**Re: Application number - SSI 13\_6136 (NorthConnex Project)**

While we support the NorthConnex project, this submission outlines our concerns that we would like addressed prior to the approval of the project by the Department of Planning and Environment.

Figure 5-38 Indicative southern interchange construction compound

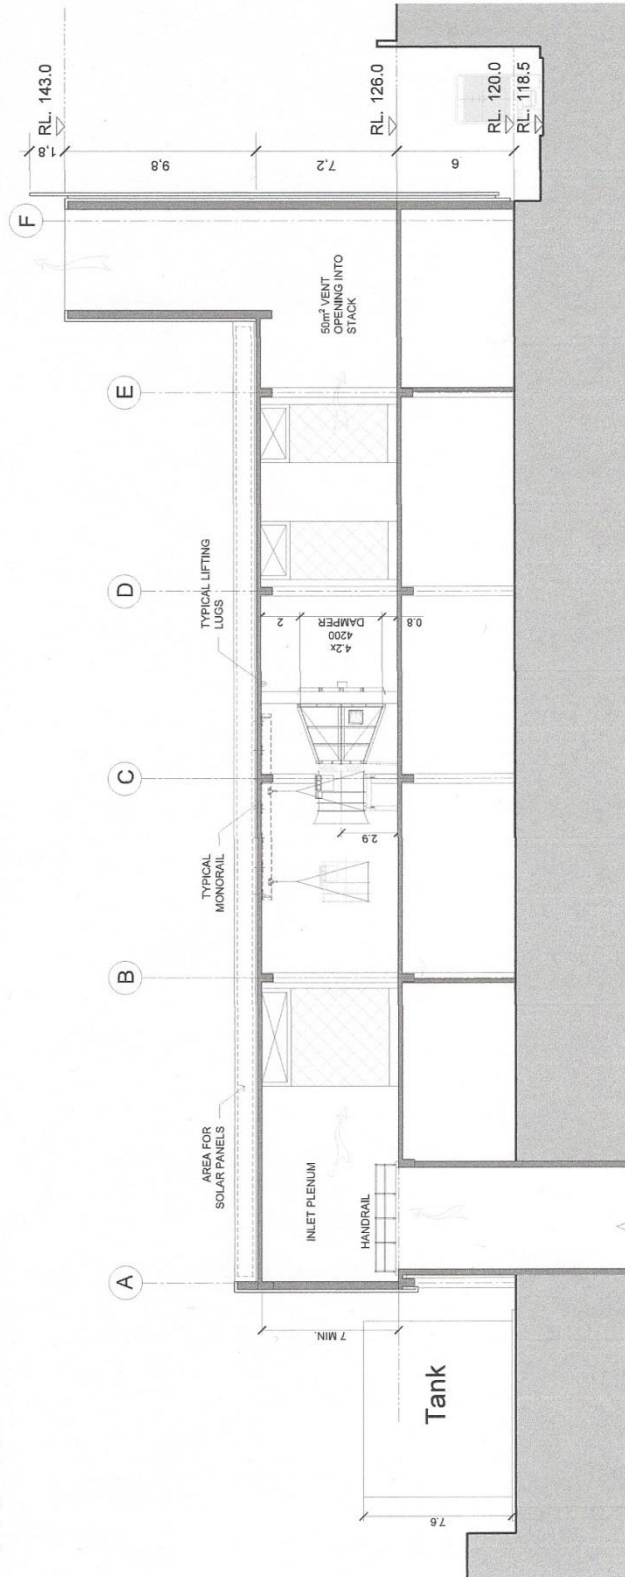
For residences adjacent to the work site, it is unclear how the work site will evolve over the duration of the project and the consideration of visual and noise impacts when positioning the entrance for tunnelling.

- Construction and noise from the surface of the work site will carry directly to our property as we are located adjacent to the site with direct line of sight. It is unclear where the entrance for tunnelling will be located and whether its location will minimise the noise impacts of the movement of heavy vehicles and the visual impact of the acoustic sheds.

- Due to the differing slope of the land between the work site and adjoining properties, it is unclear what excavation works are expected, if any access is required via private property, the ground levels between the interchange and adjoining properties during and post construction and where and at what level temporary fencing will be constructed.

- It is unclear the maturity of plants which will be used to provide privacy and screening between the Southern Interchange and adjoining private properties. As our property will be directly adjacent to the car park, we would like ensure that adequate mature plants and screening be used to protect our privacy.
